WOODMEN HILLS REC CENTER
9205 MERIDIAN RANCH ROAD
EL PASO COUNTY, COLORADO

JOB NUMBER	953-20
REVISIONS	
ORIGINAL DATE	10-1-20
DRAWN BY	JM
DESCRIPTION	LANDSCAPE PLAN
SHEET NO.	L1.1

Landscape Plan drawings v_1.pdf Markup Summary

**OVERALL LANDSCAPE PLAN**

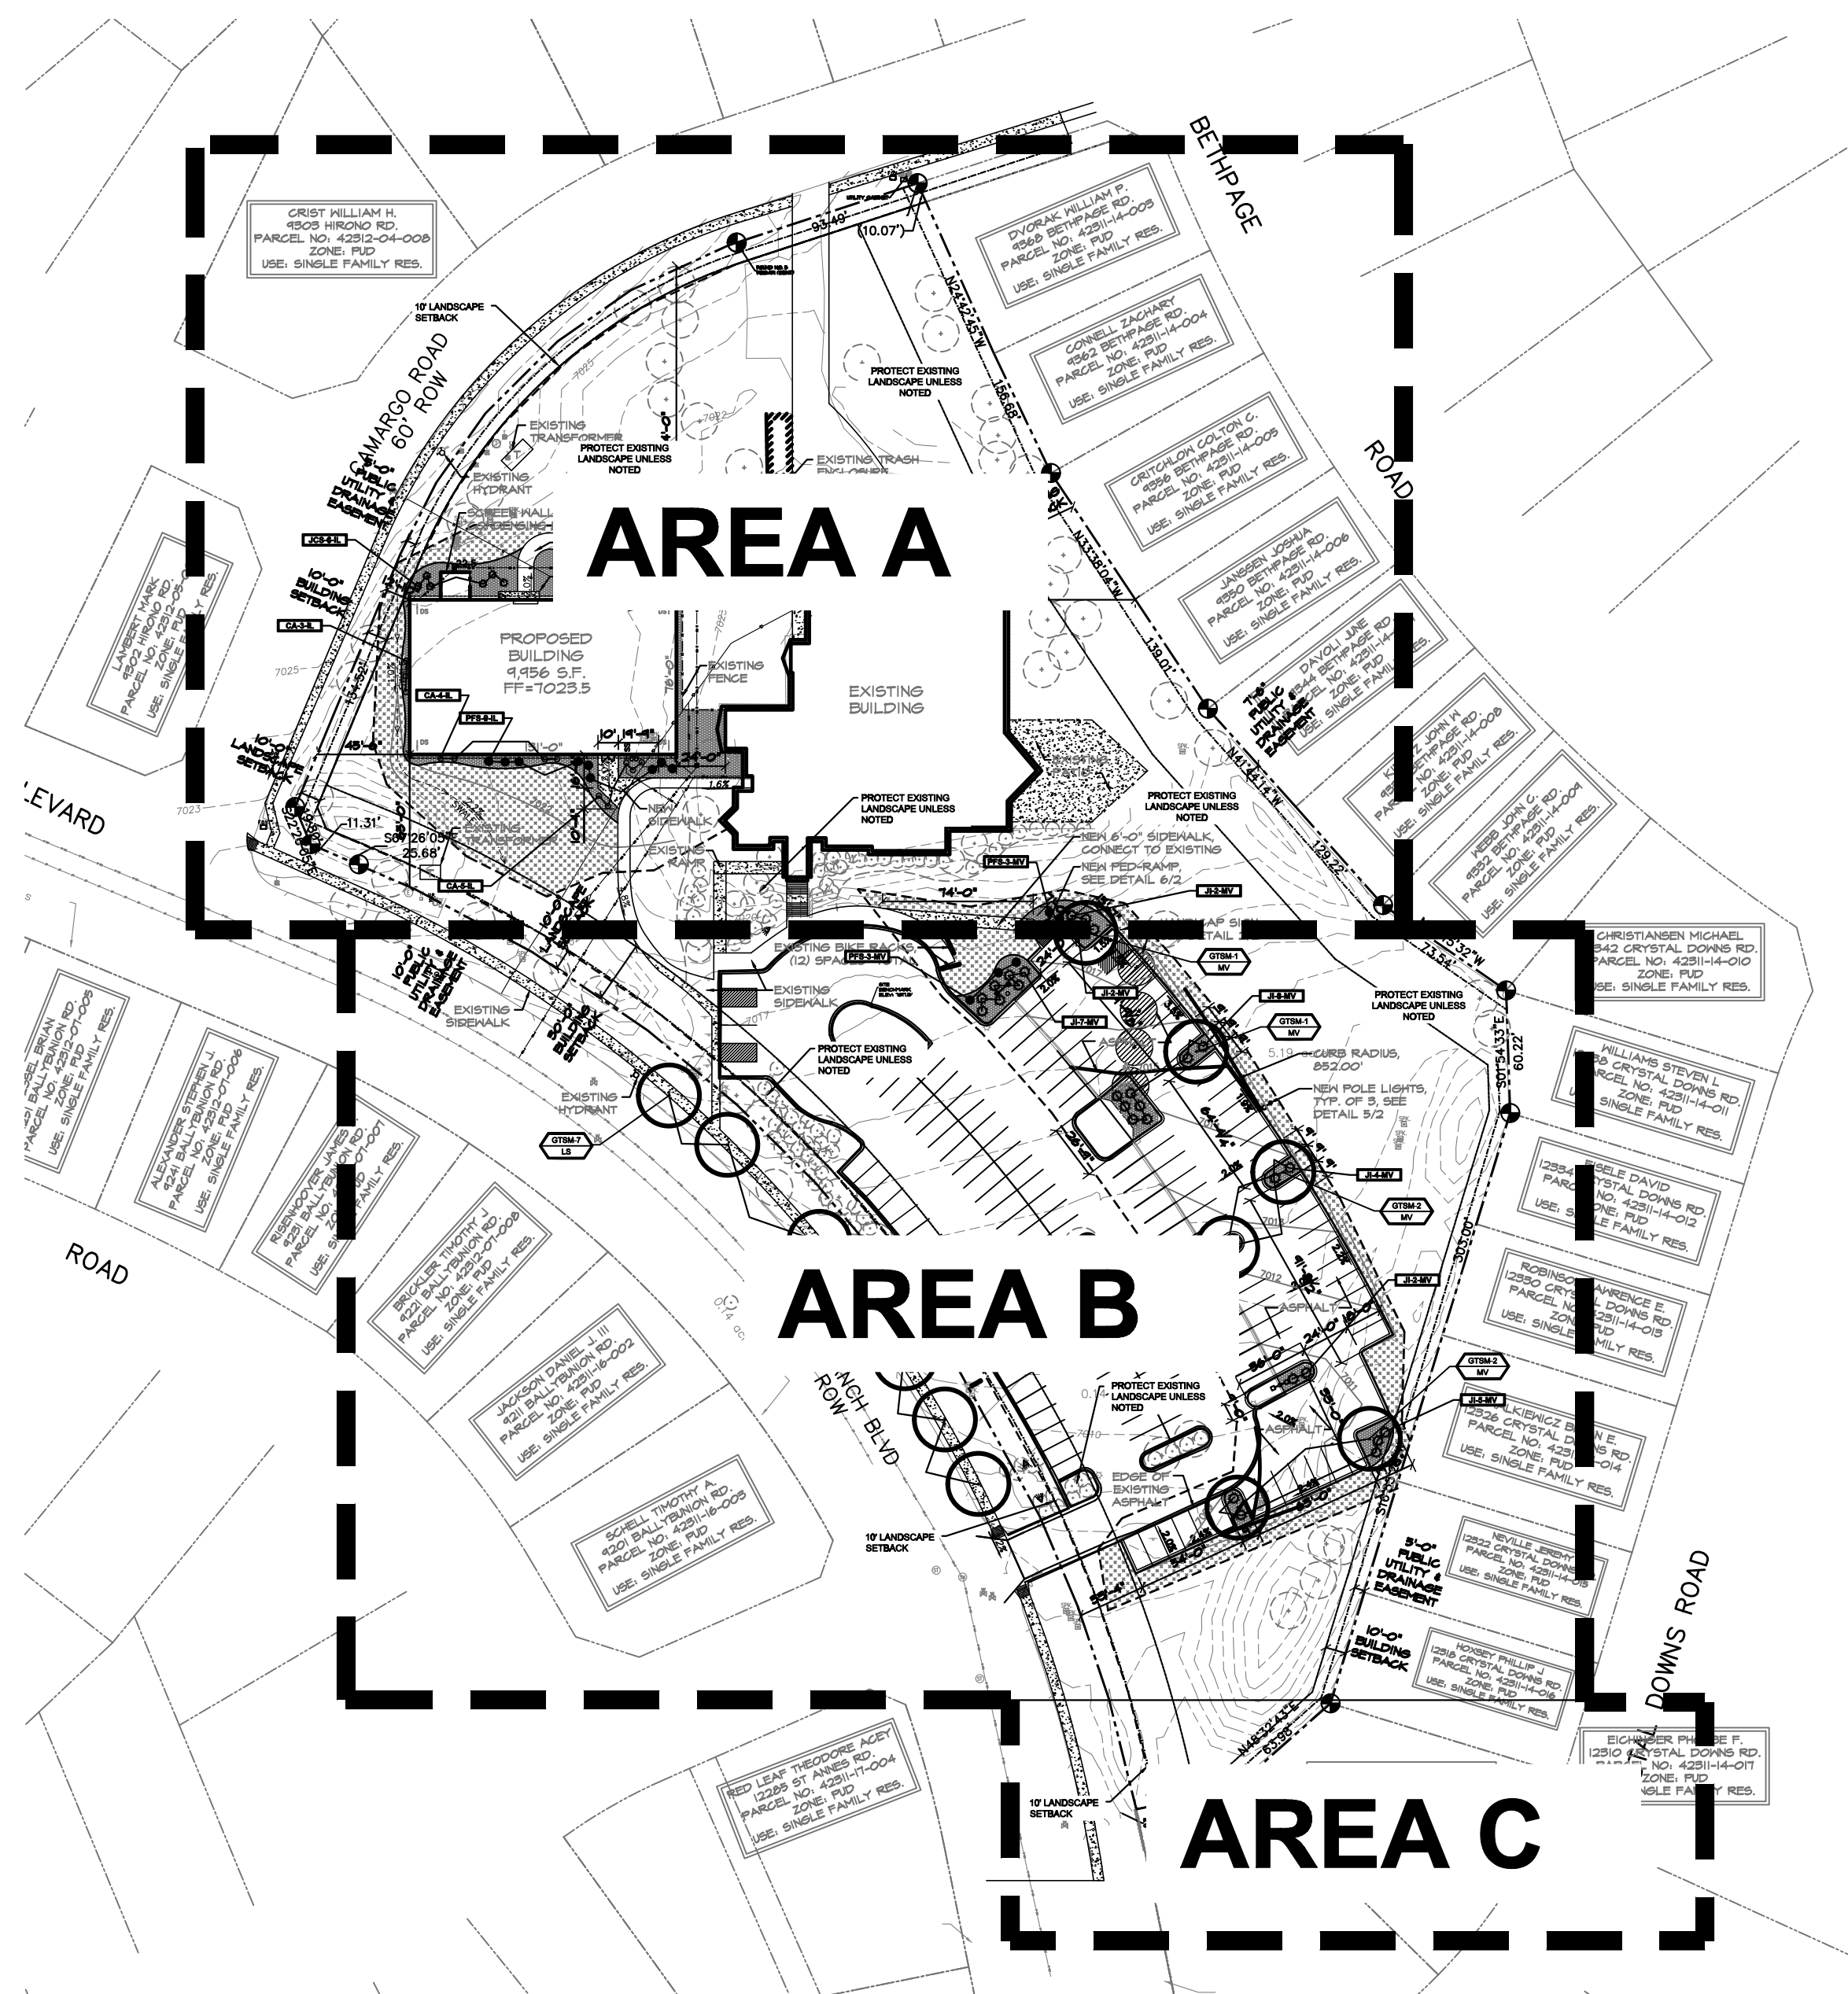
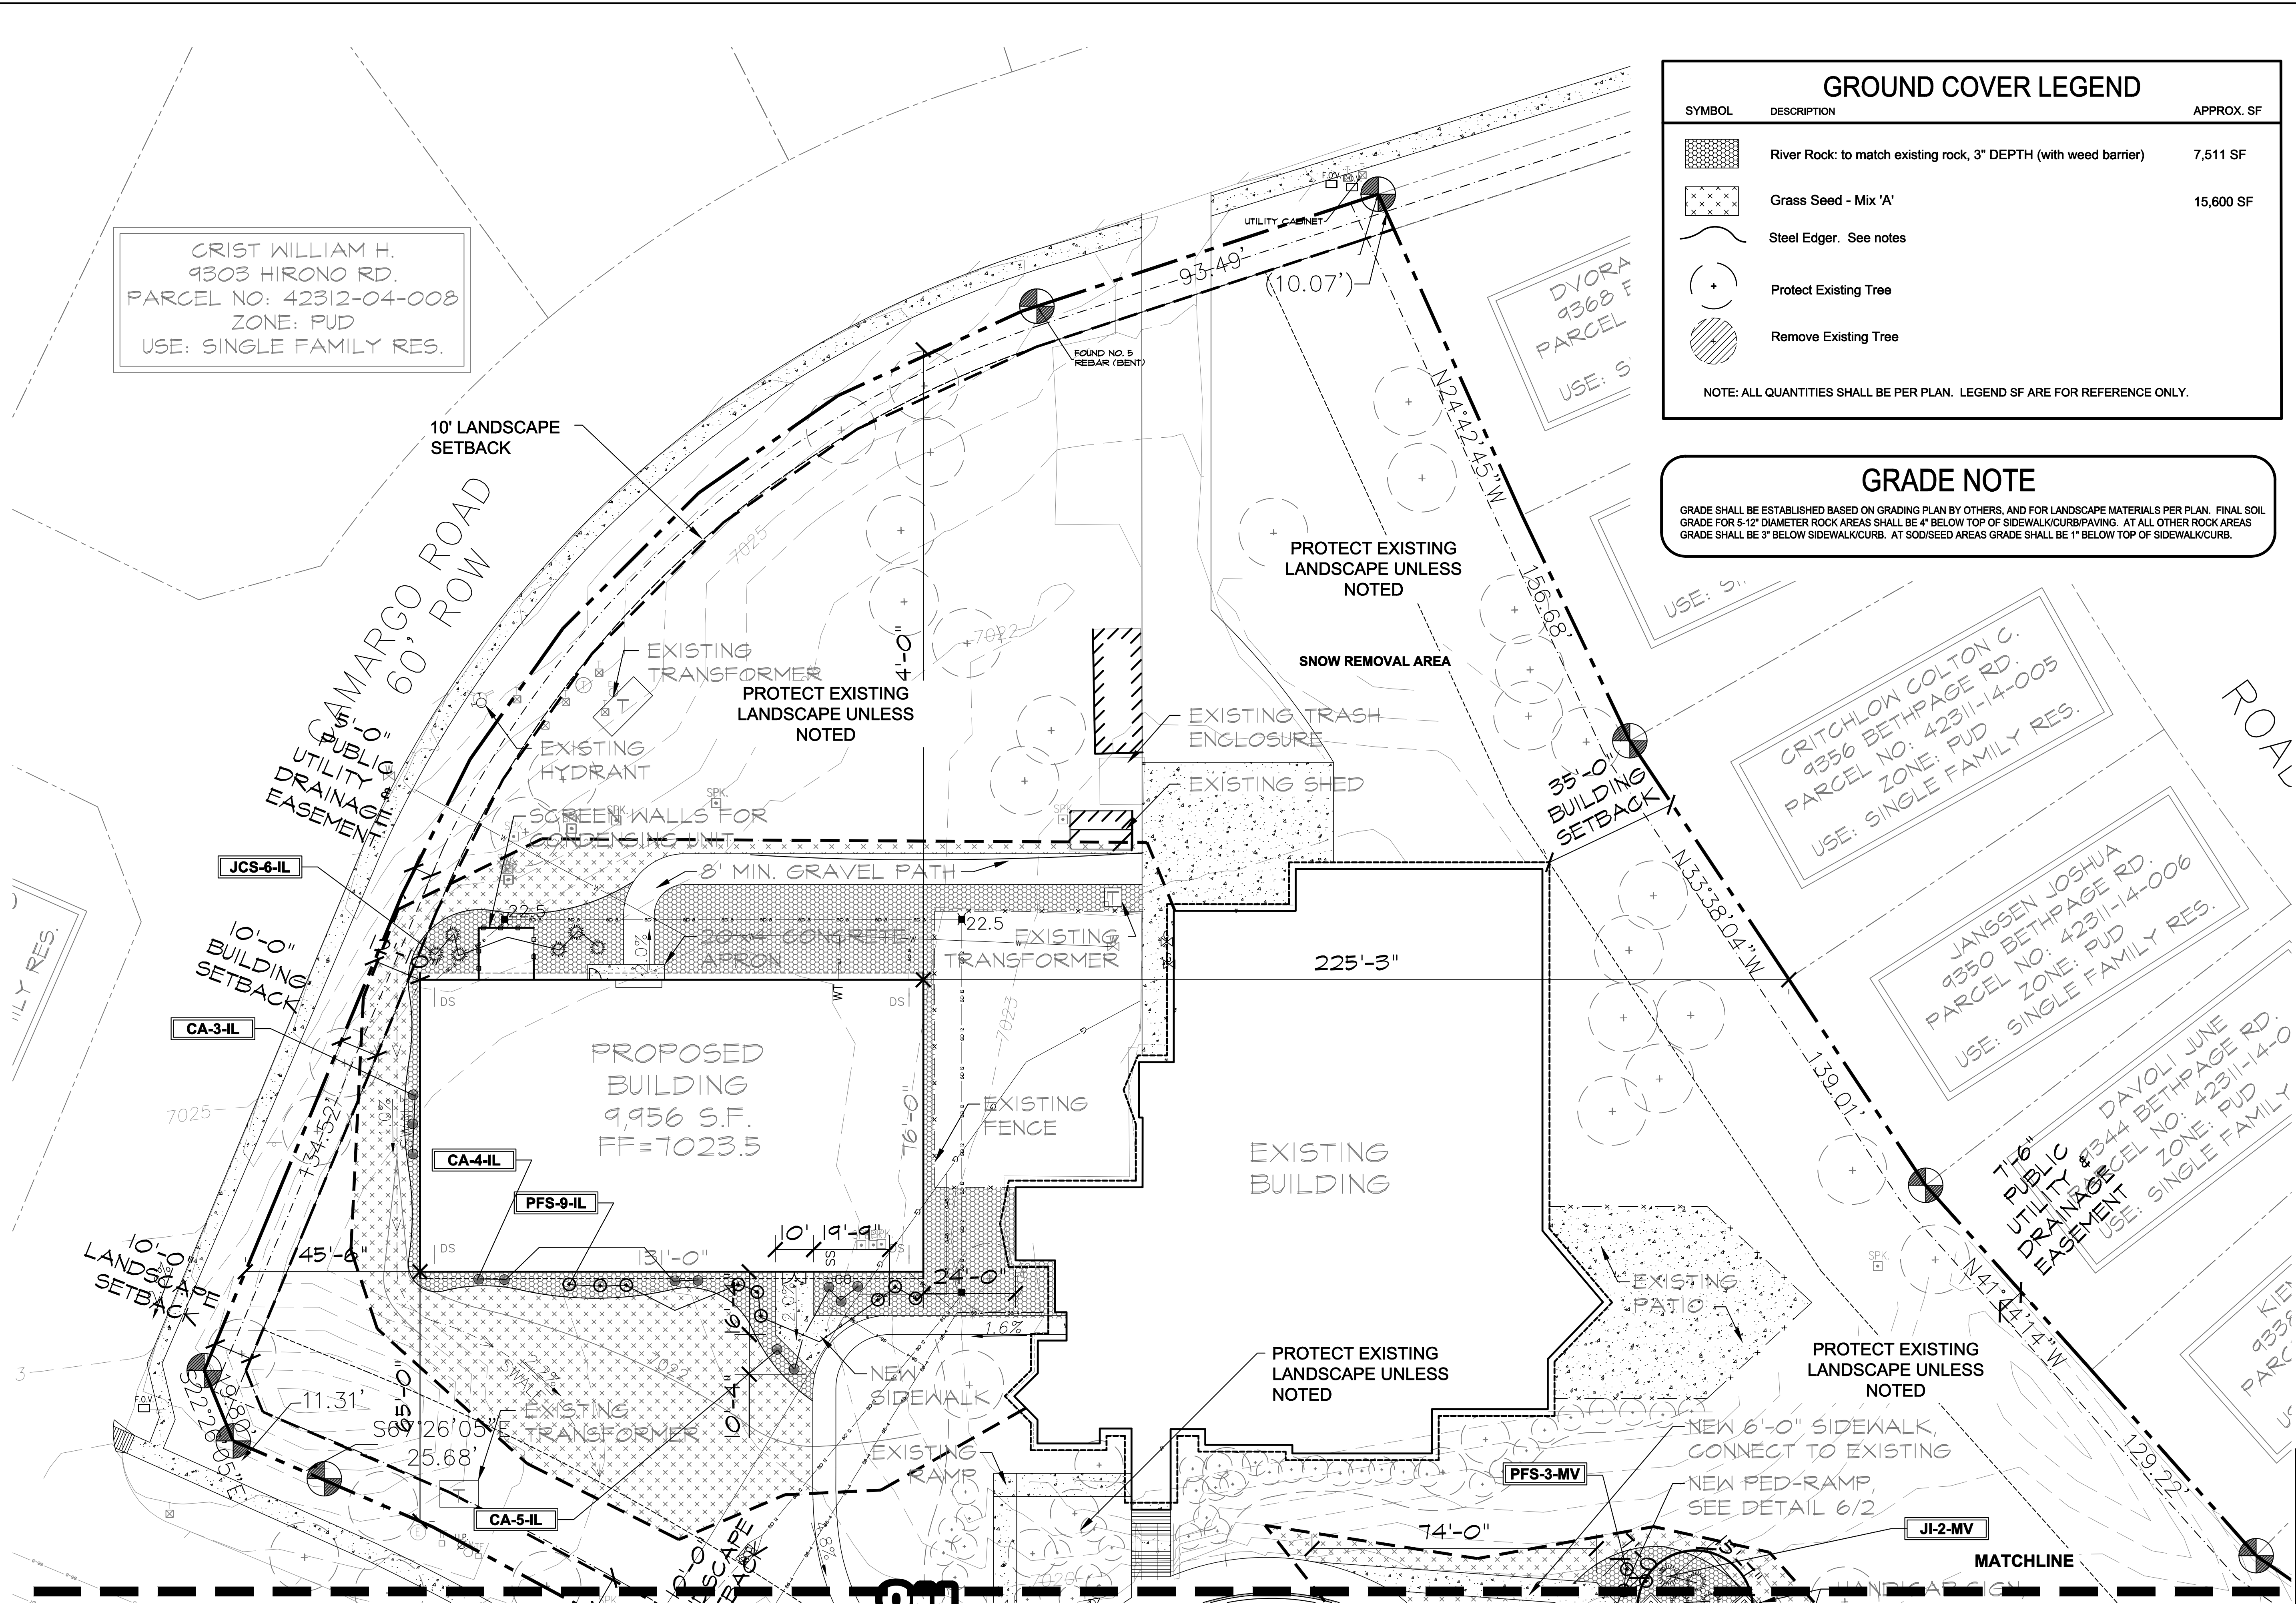
Please refer to Land Development Code Chapter 6 - Table 6-1 for roadway landscaping requirements by roadway classification. Note that the Camargo is Urban Local and Meridian Ranch Blvd is an Urban Non-Residential Collector
